FROM DESIGNER: Stephen Sanderson, P.E.
 DATE: 6/14/05
 Job Name: 115 Sherwood Remodel
 Address of Construction: 115 Sherwood

Mike Nugent - 115 Sherman St. Plans

From: Mike Nugent
To: Mindy and Stephen
Subject: 115 Sherman St. Plans

REAR ELEVATION  
SCALE 3/8\"/>

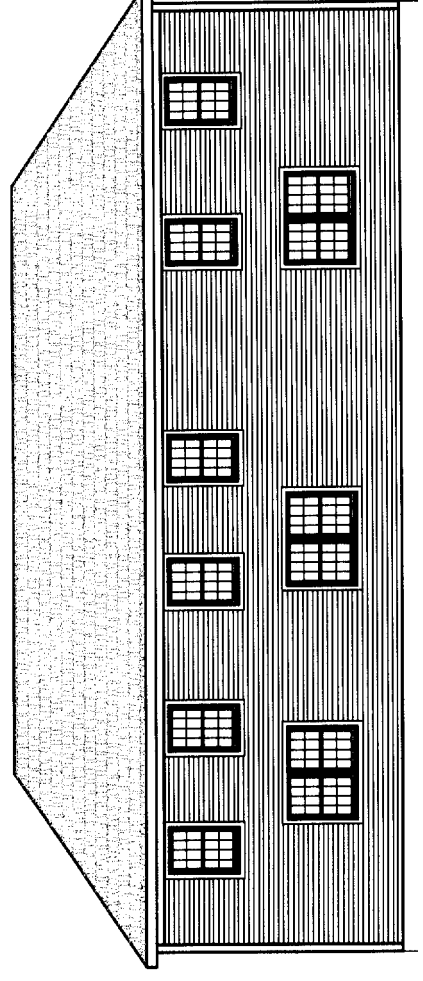
- 1) The roof framing detail for the new addition that is a Gambrel type lacks sufficient detail structurally..i.e. ridge info etc.
- 2) Attic Access is 22" by 30" (20"x 30" shown) and needs to be above every unit, where will it be?
- 3) The headers above the sliders are under designed.
- 4) A 9" tread and a 8 1/4 " (page A-9) rise do not comply with the 2003 *IRC*.
- 5) We are going to have to discuss the rear wall and fire separation and openings, It's only 6" from the lot line.
